**West Yorkshire Police  
Kirklees District**

**Architectural Liaison Officer**

| To: Louise Bearcroft<br>Investment & Regeneration Service<br>Kirklees Council<br>Civic Centre 1, Huddersfield, HD1 2EY | Ref: 2016/62/91887/E<br>Date: 10 <sup>th</sup> August 2016 |

**Crown Hotel, Chickenley, Dewsbury  
Demolition of existing public house and erection of 9 dwellings with car parking**

Dwg Title:
Proposed Site Plan

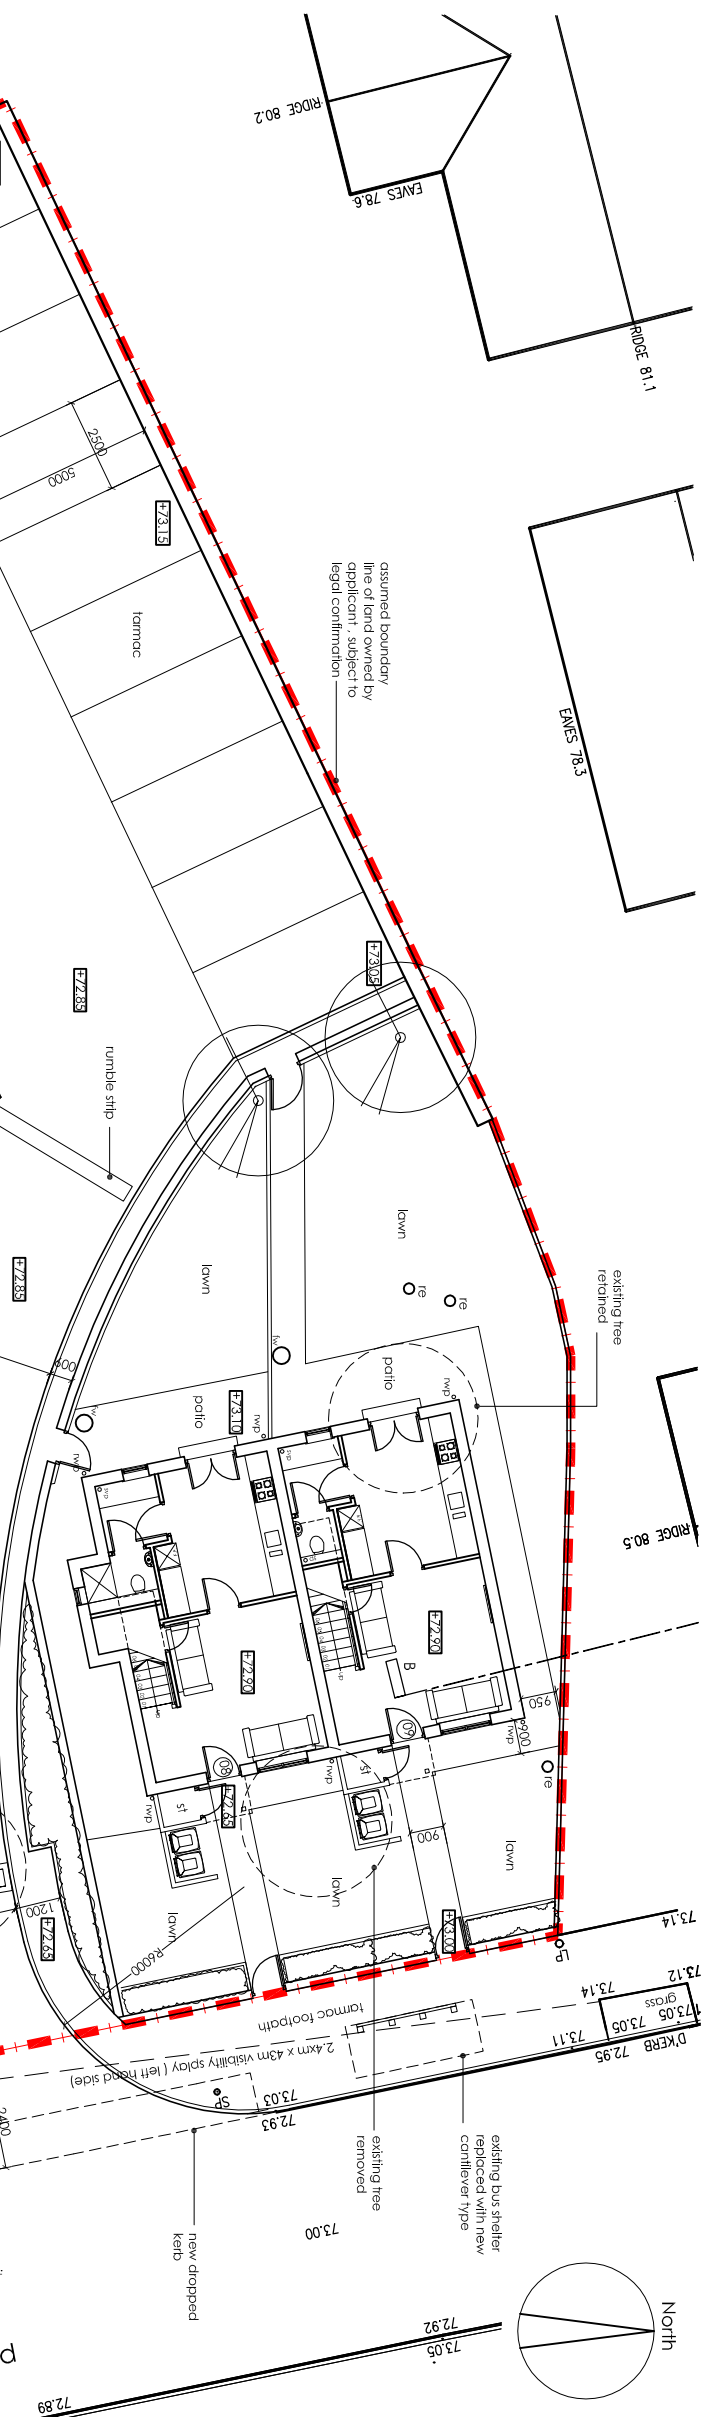
There should be no enclosed shared footpaths that give access to the rear of a large number of dwellings.

In the layout as shown, it appears that five of the houses would have such a footpath running adjacent to their rear or side, enclosed and unobserved between tall, timber rear garden fencing.

The remaining houses would also back on to a publicly accessible footpath, which, whilst not enclosed, would itself be inadequately overlooked.

Shared rear access paths inevitably raise the opportunity for burglary, and at the very least are likely to become littered, neglected areas with forbidding passageways of tall timber fencing that gets damaged. In addition, the fear of crime amongst residents would be heightened, and this alley could become a hidden congregating area where various antisocial behaviour activity takes place.

An alternative arrangement should be designed.

The area shown for car parking is effectively a rear parking court which would be largely hidden (by rear garden fencing) from the view of residents. The only overlooking from houses is likely to be from first floor (bedroom) windows, which do not provide active, routine surveillance.

Such rear parking courts can be vulnerable to crime and antisocial behaviour as they can introduce uninhibited access to the rear of houses, raising the opportunity for burglary as well as car crime.

An alternative arrangement, giving in-curtilage parking would be preferable.
